CITY OF ALBUQUERQUE

September 15, 2021

**RE: McMahon Market Place – Lot 9B, 9C, & 9D Improvements
Conceptual Grading and Drainage Plan
Engineer's Stamp Date: 07/15/21
Hydrology File: A11D011I**

Based upon the information provided in your submittal received 08/09/2021, the Conceptual Grading & Drainage Plan is approved for action by the DRB on Site Plan for Building Permit.

SHEET NO:
CG1.1

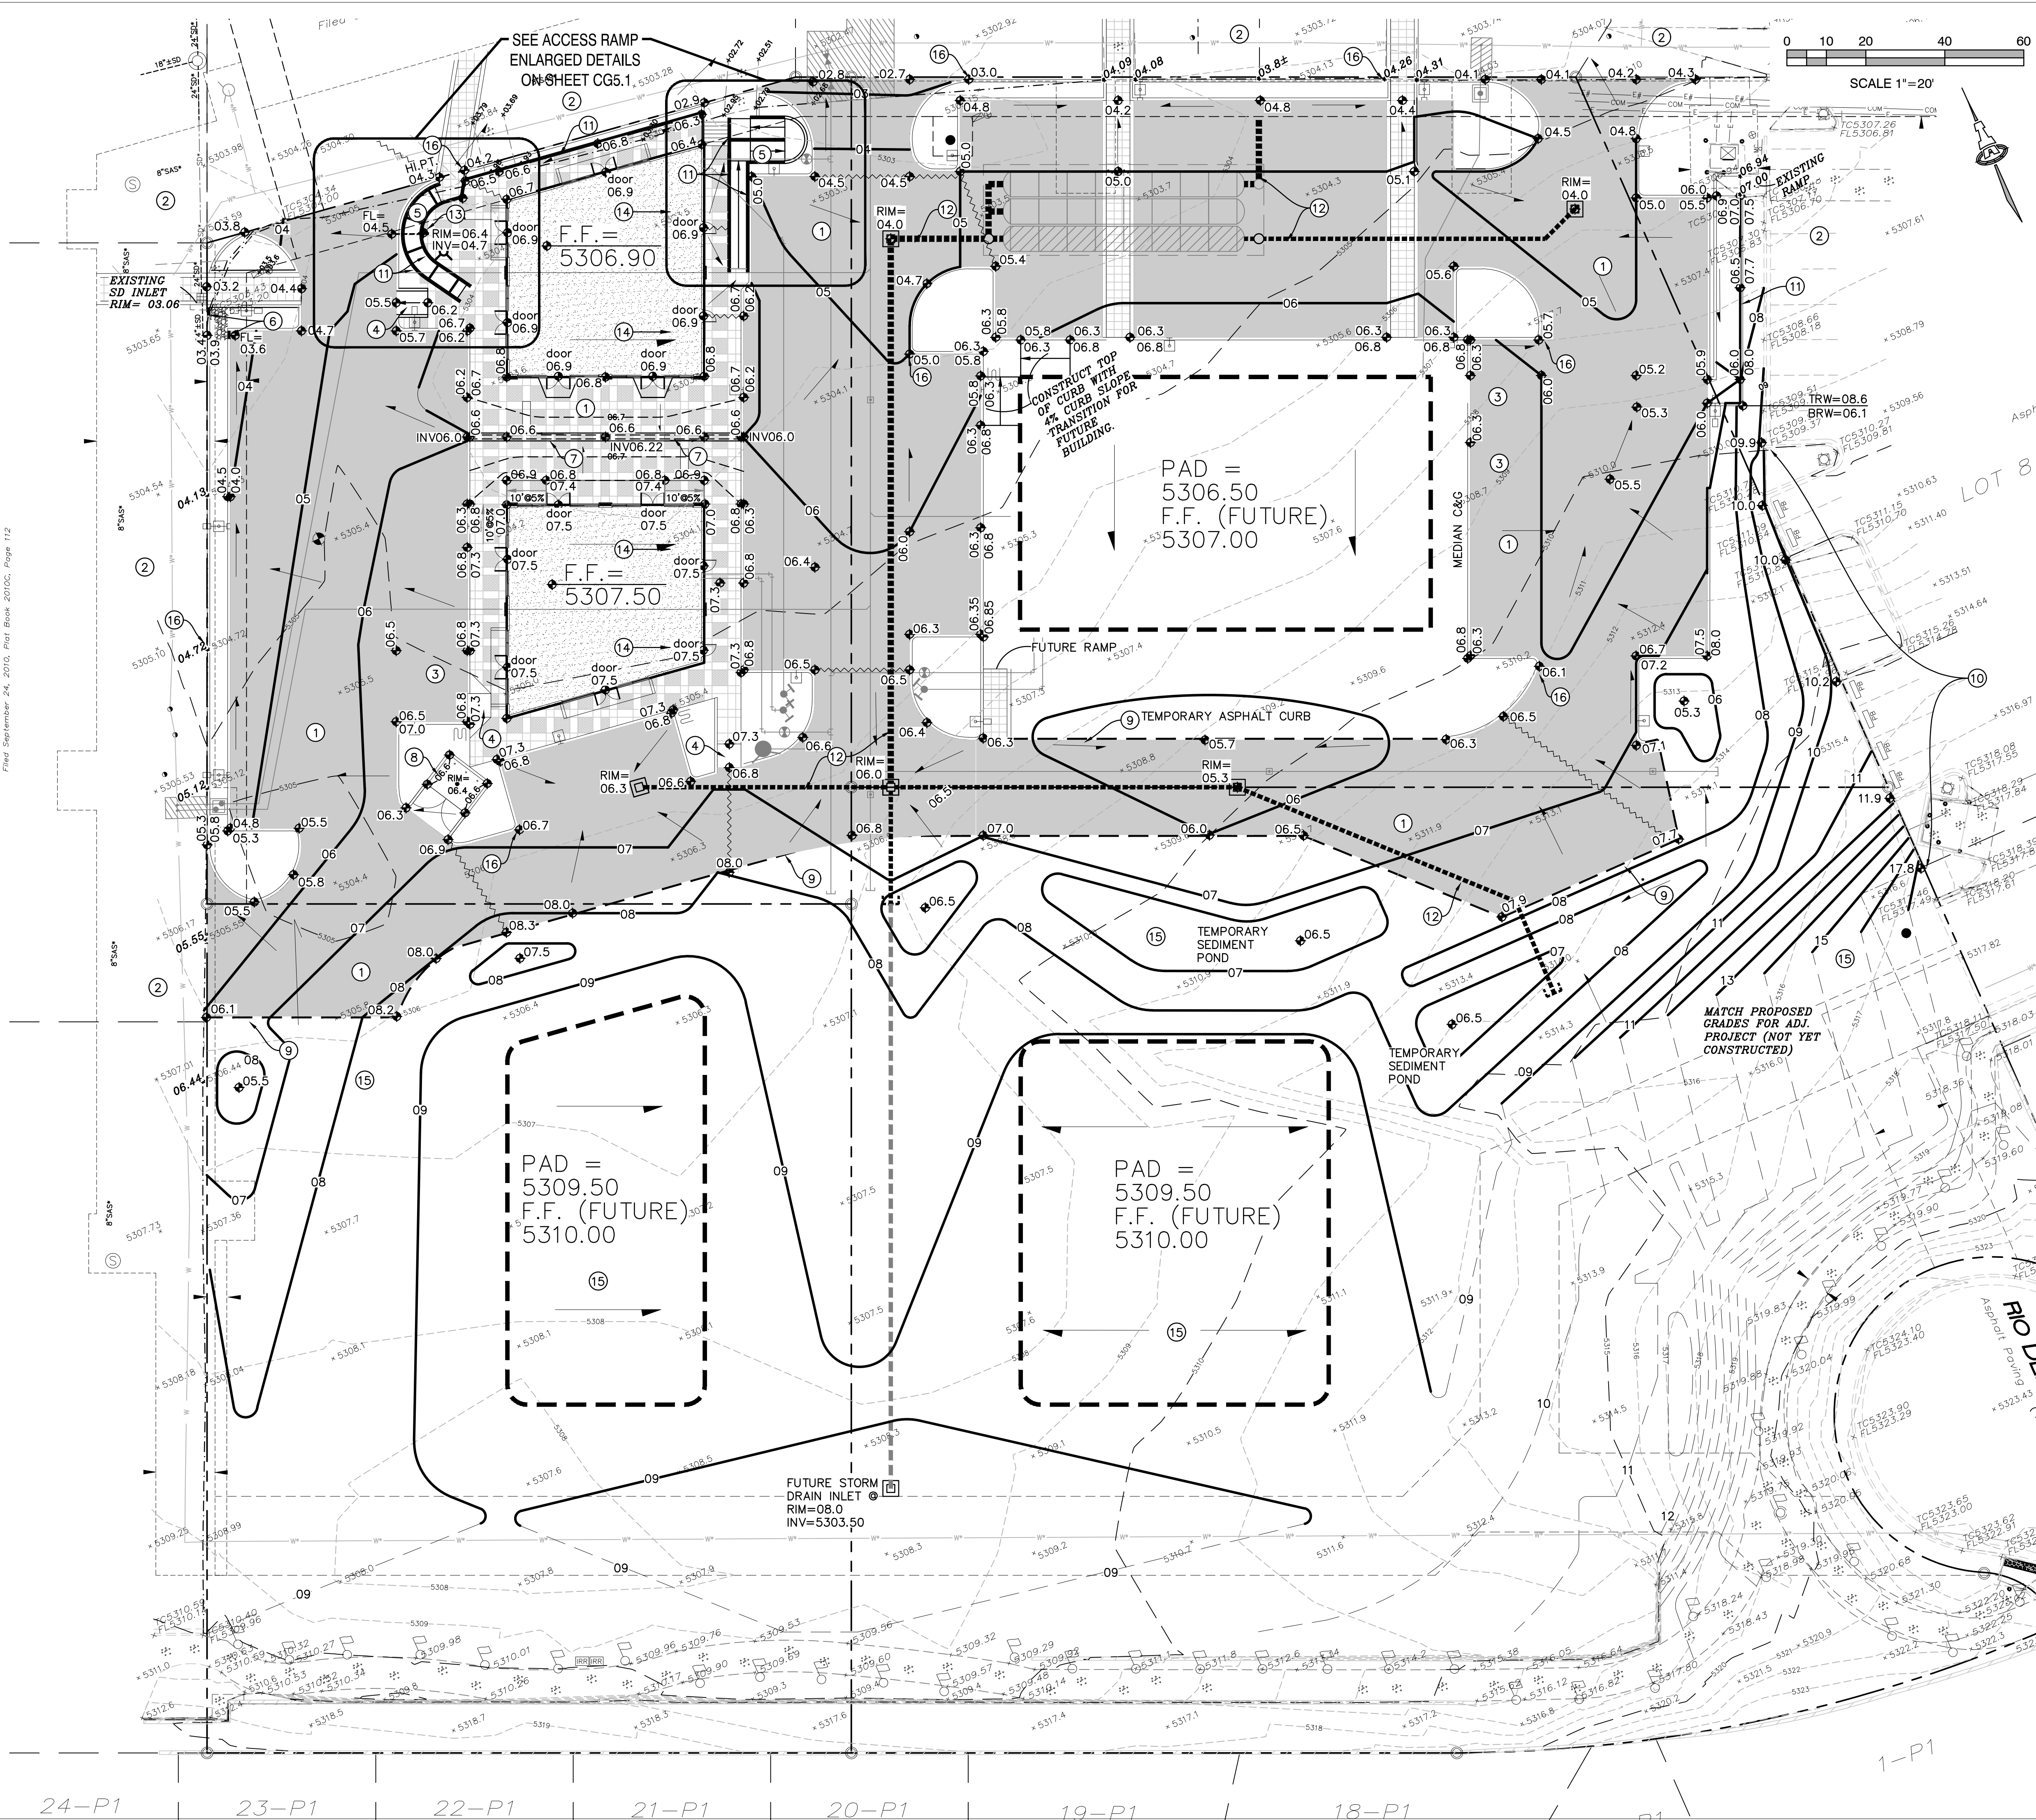
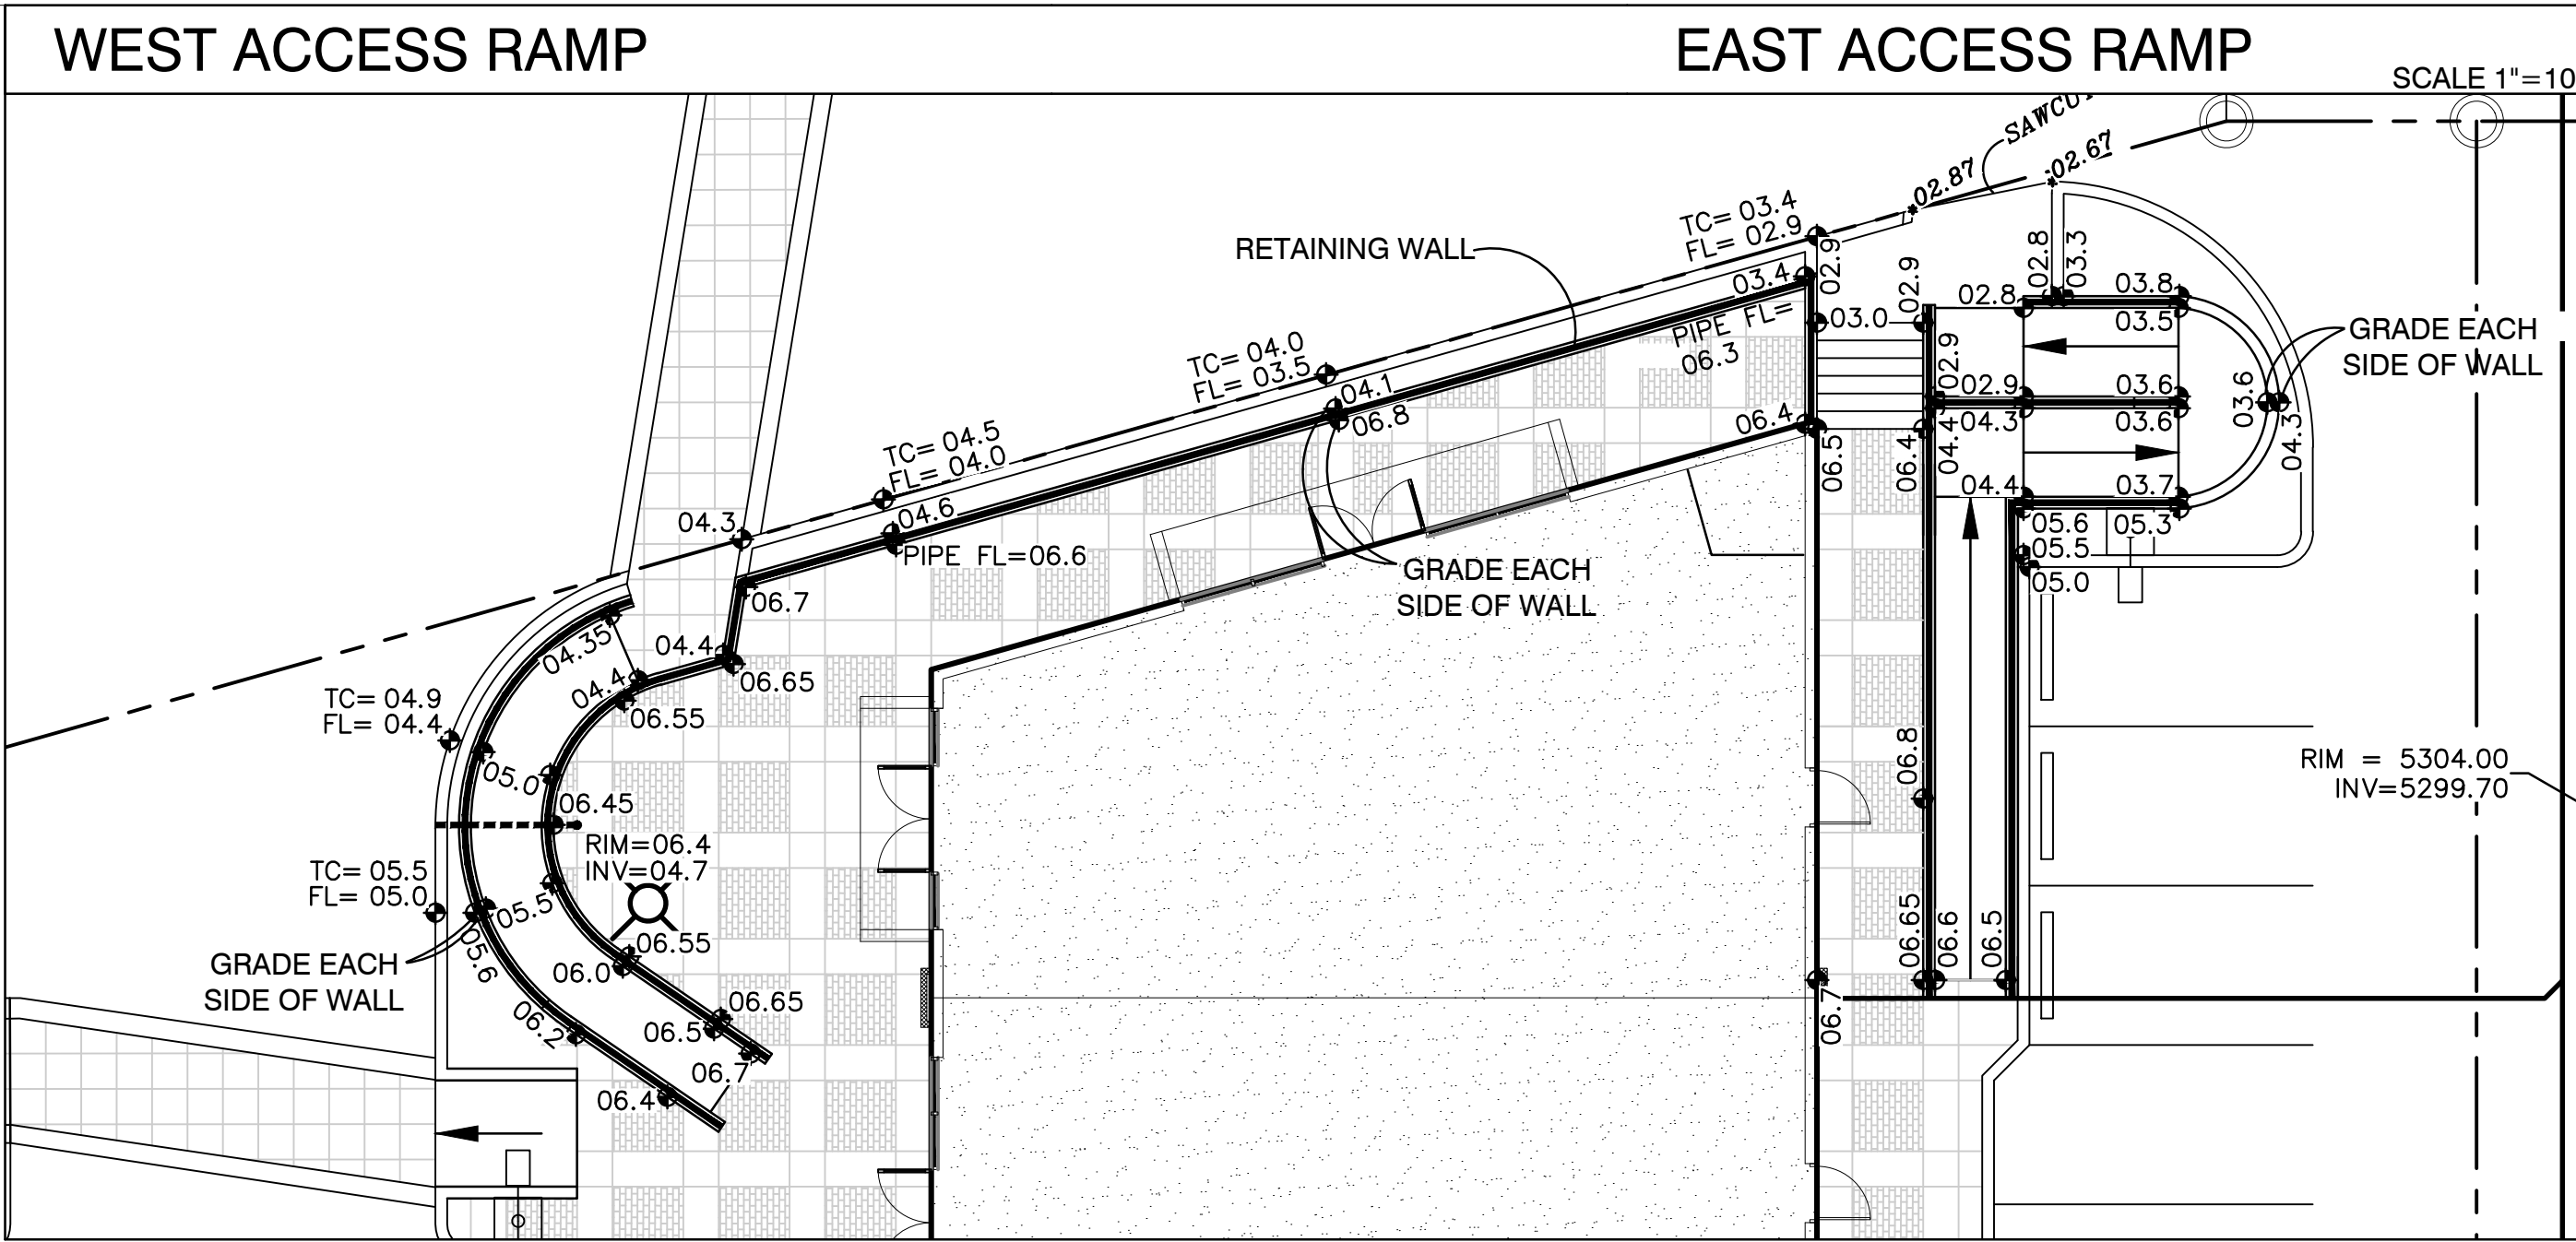
- Also there is currently storm drain system that Lots 9C & 9D are to tie into based on the last design for this area. (see As-built for Lot 9A)
